From: [David Kindel](#)
To: [Harmon Rita T.](#)
Subject: FW: FW: 512 Yale
Date: Thursday, April 21, 2016 6:43:38 AM

> · I cannot tell where the property line is. There are 2 references.

Drawing file: K15D099 / 15013 -AS101-Layout1 (2).pdf

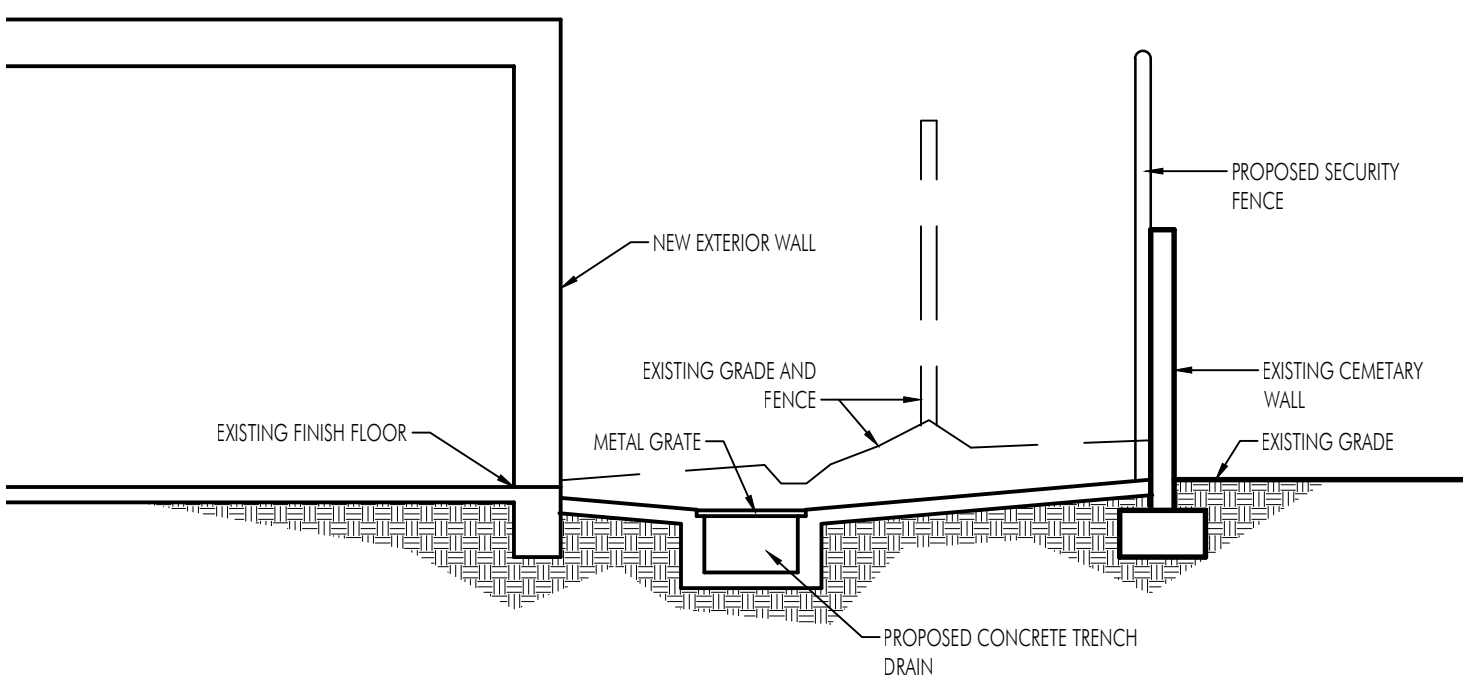
> · The Utility easement appears to on property for 512 Yale, is this

> · What is the meaning of the dash-dot-dash lines? There are 3 lines
